McDowell Consulting Engineers, Inc.

June 7, 2019

Re: YMCA of Harnett County

Addenda Items:

1 OVERALL PLAN - ELECTRICAL
E2 SCALE: 3/32" = 1'-0"

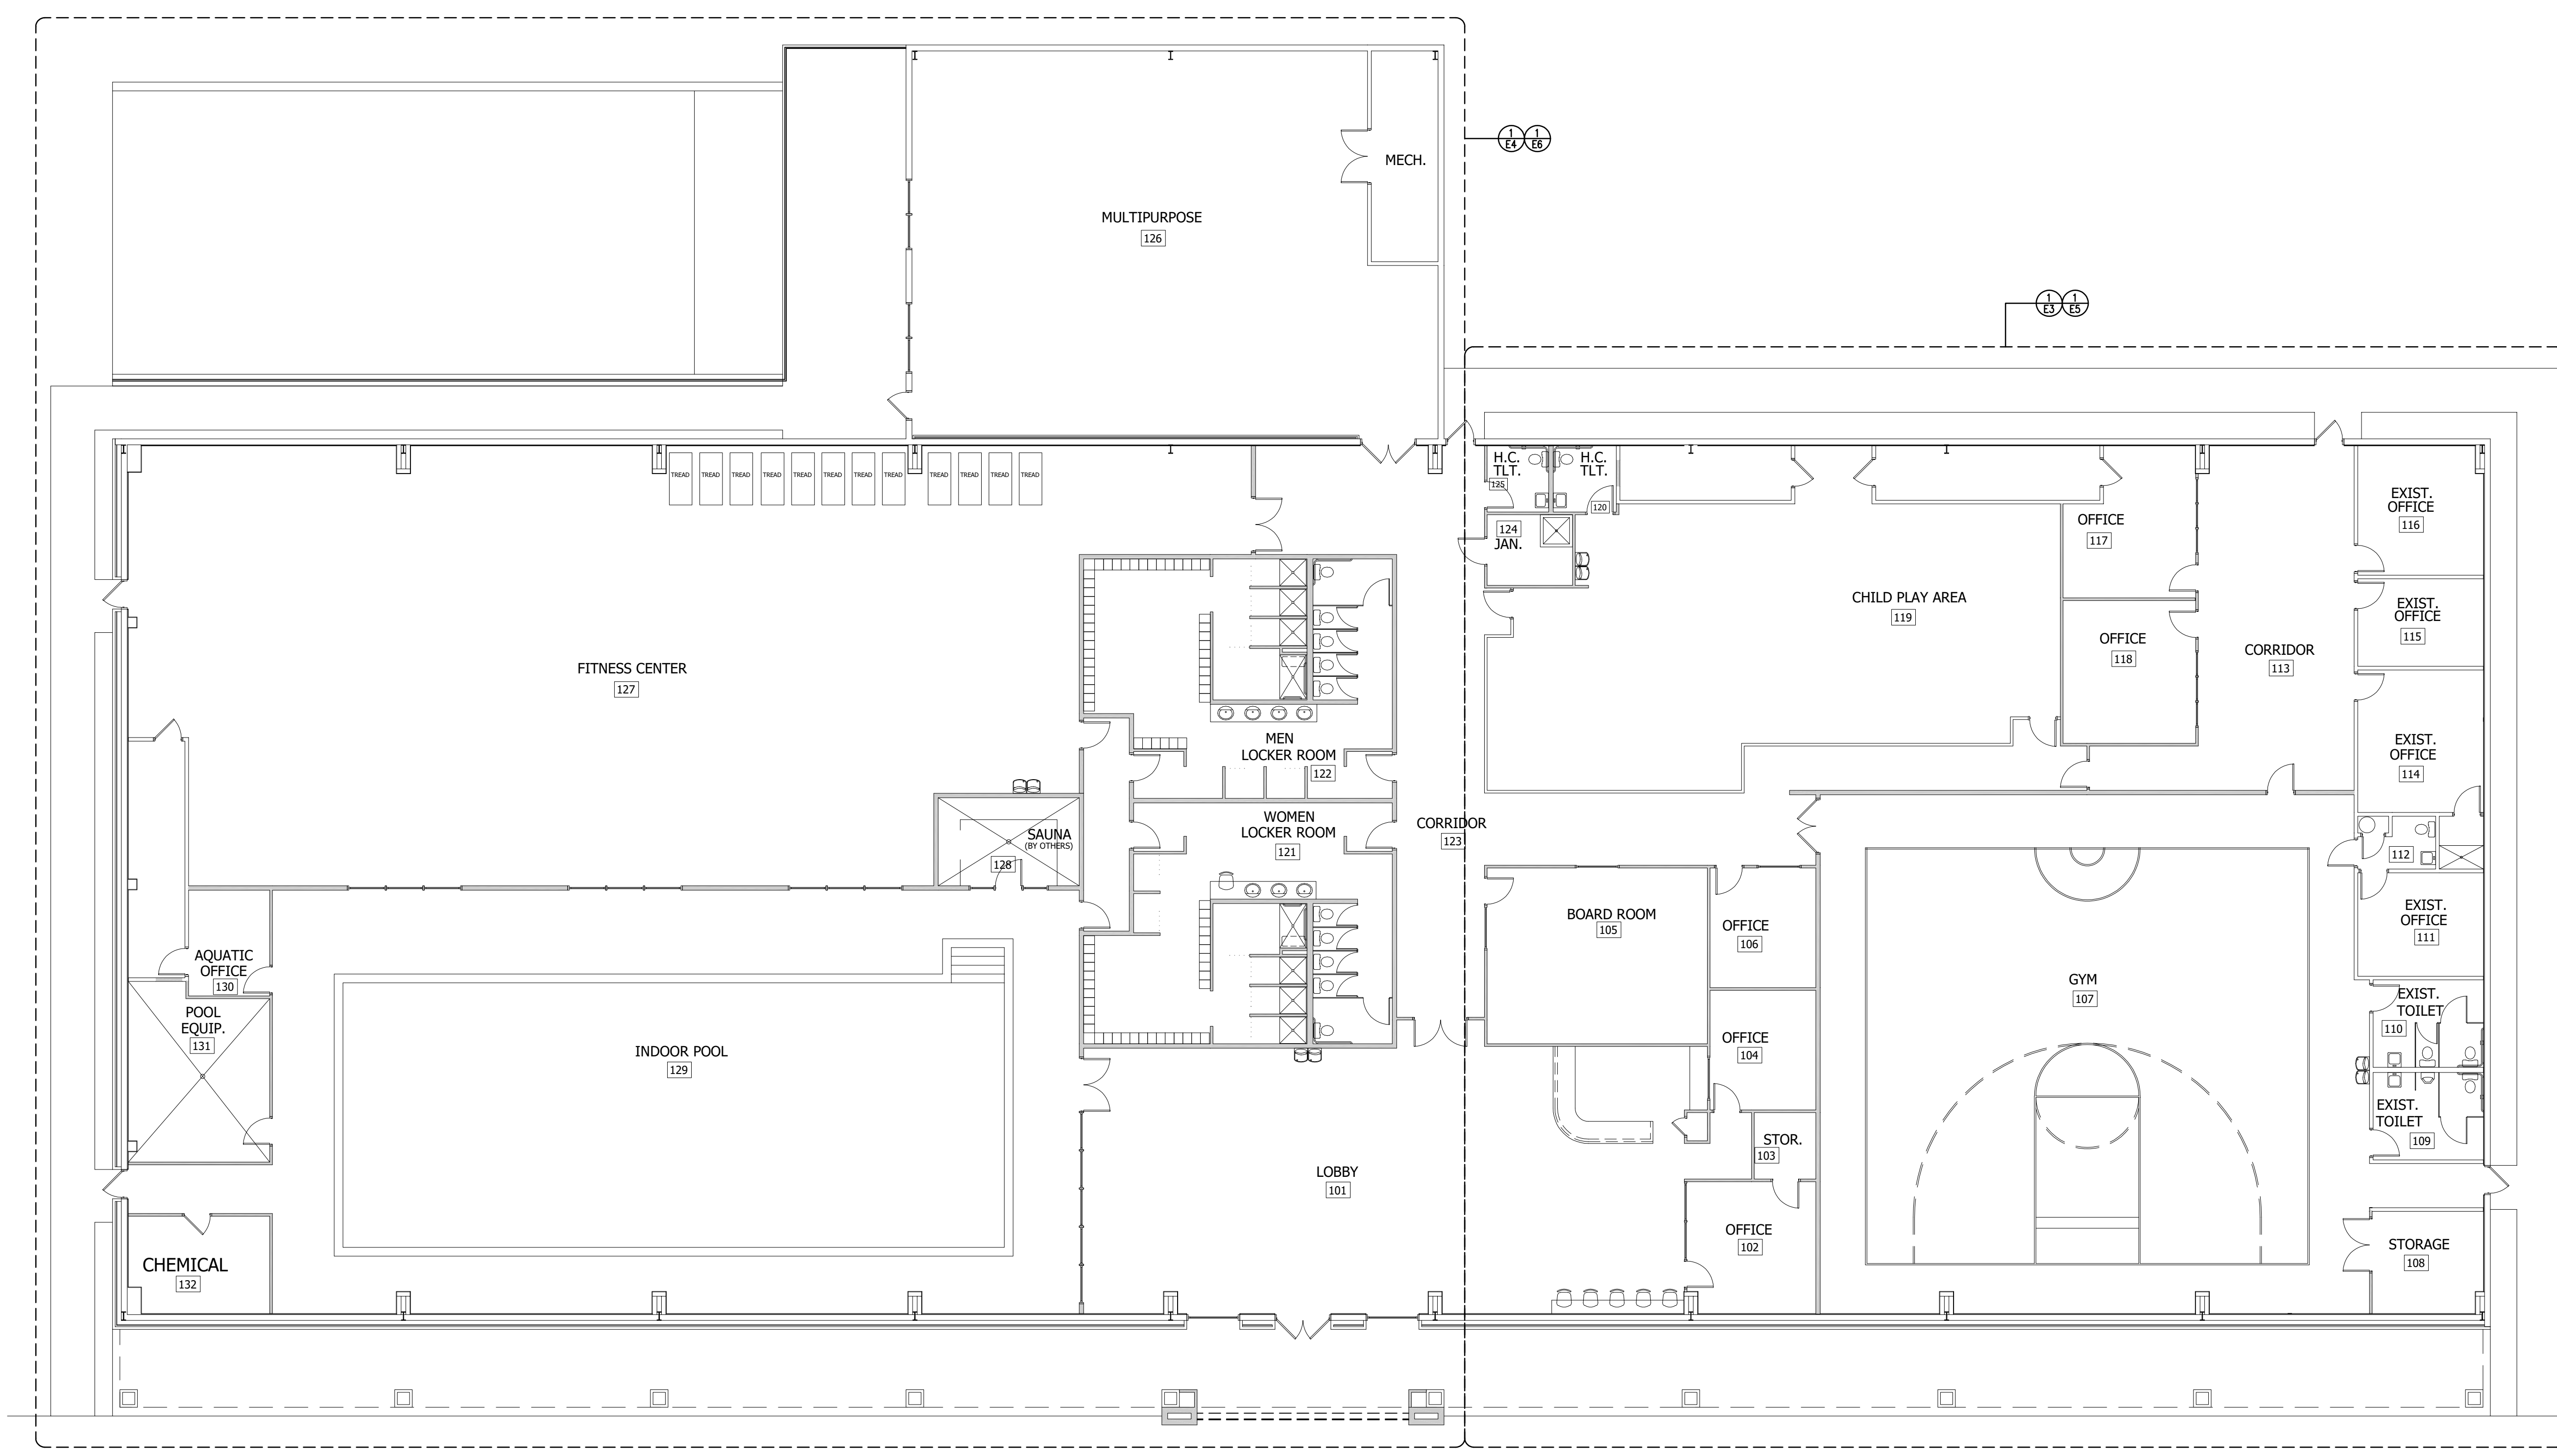
Existing 480/277 volt lighting panel "A" can remain in place as the wall will not be removed.

YMCA OF HARNETT COUNTY
 107 CARLETTA DAGLE DRIVE
 CAMERON, NORTH CAROLINA
 PROJECT # 18123
PARTIAL PLAN - LIGHTING

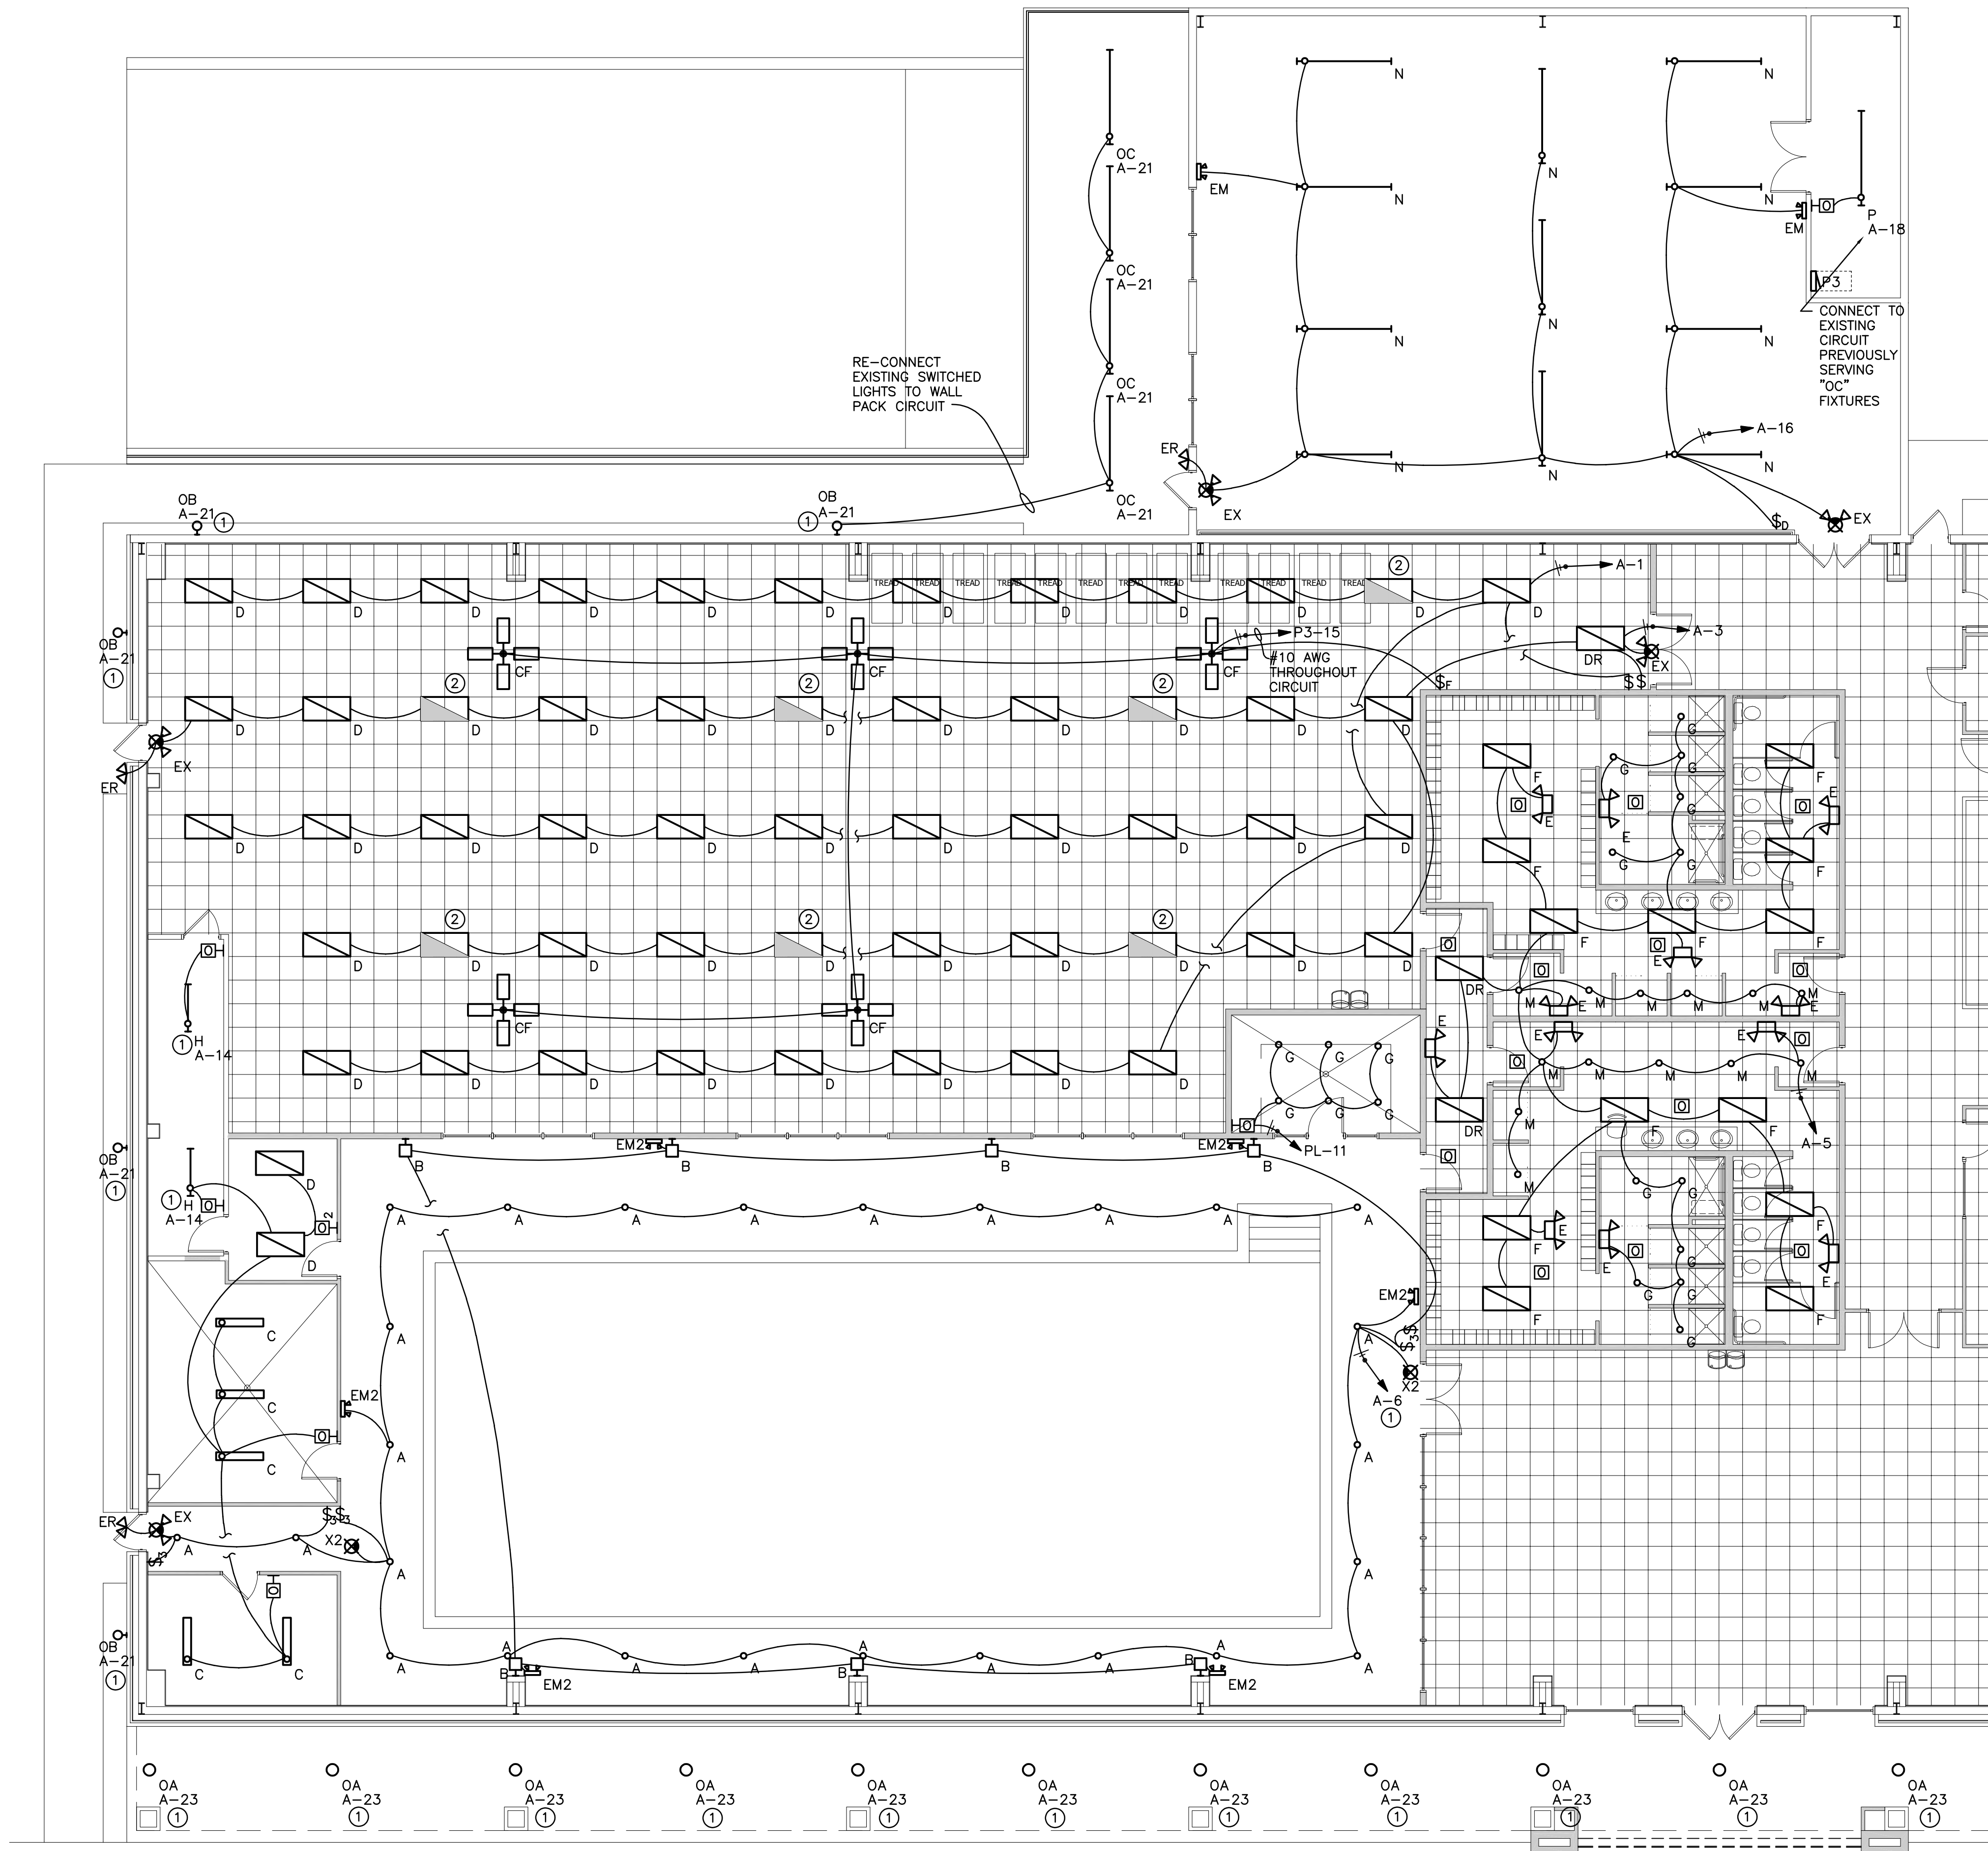
Replace all fixtures noted in fixture schedule as existing with new equivalent lumen LED fixtures.
